Date 2 October 2023
Our Ref 23/01136/FLH

Town and Country Planning Act 1990 (As Amended)
10 Shadbolt Close, Worcester Park, Surrey
Single storey front porch extension

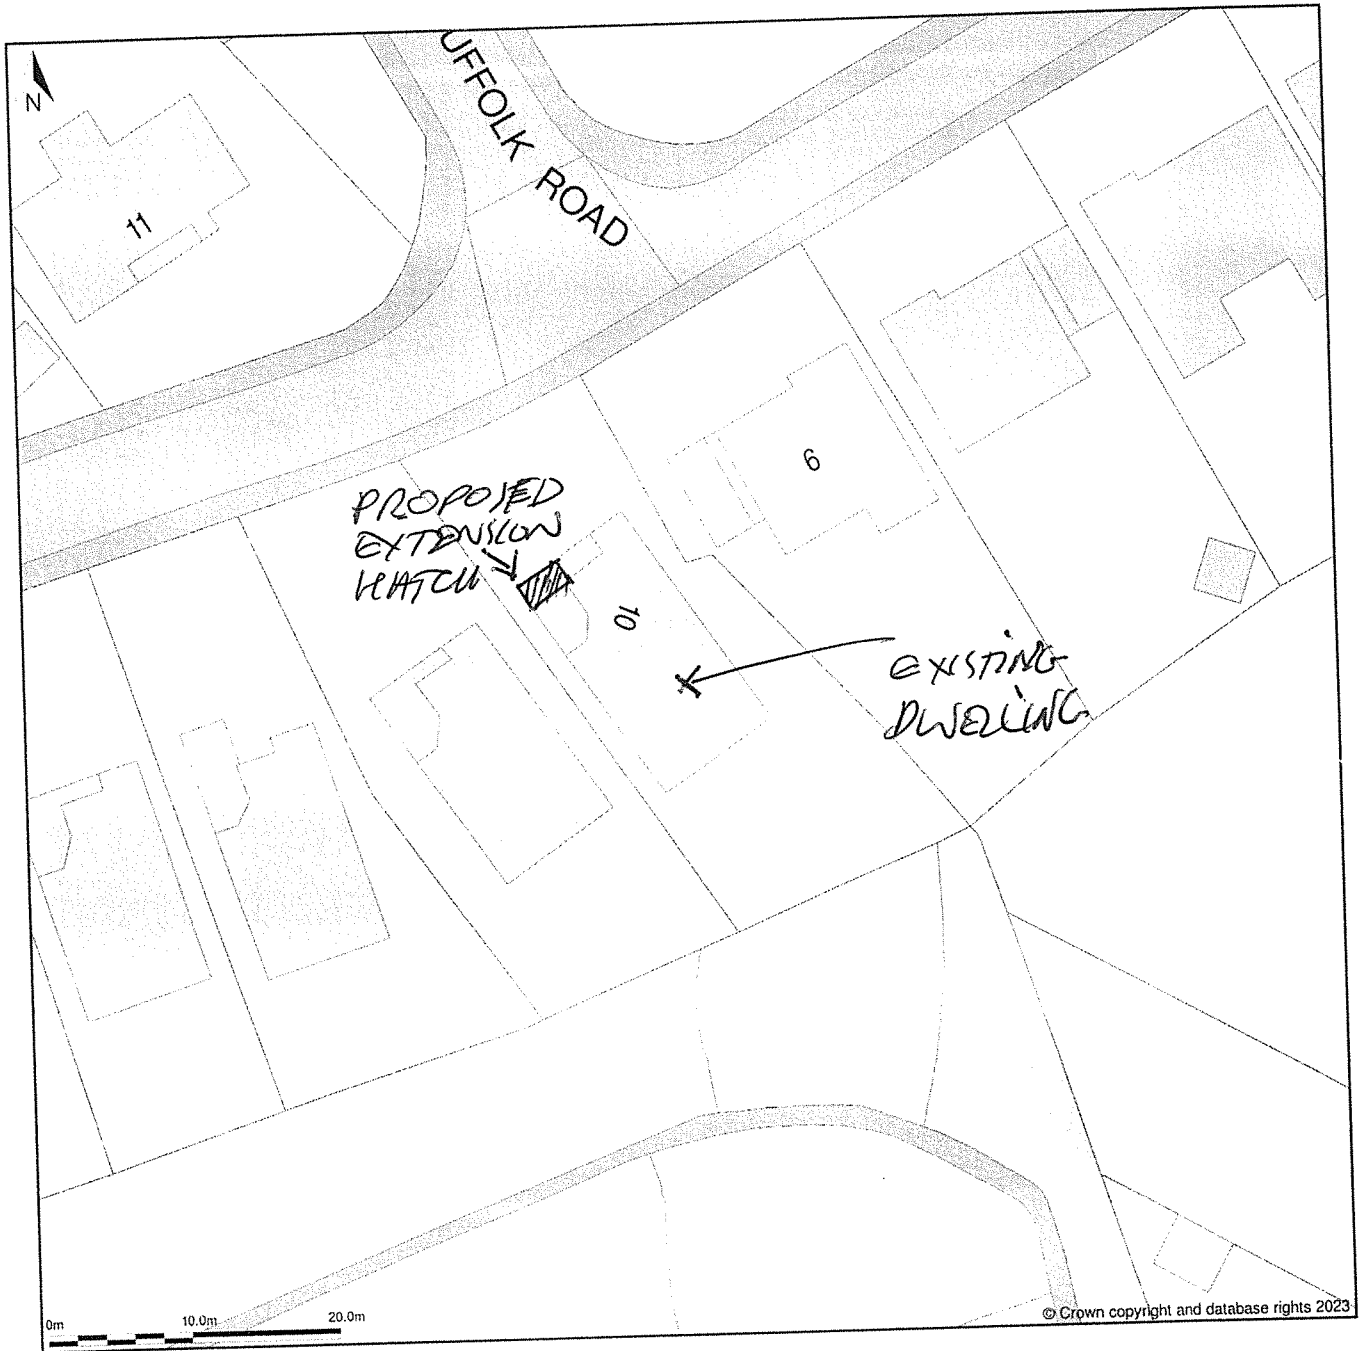
2 Please submit a proposed Site Plan at a scale of 1:200 or 1:500 showing the proposal, clearly differentiate from the existing (e.g. hatched) and its relation to the site boundaries, any other existing buildings on site and the neighbouring properties.
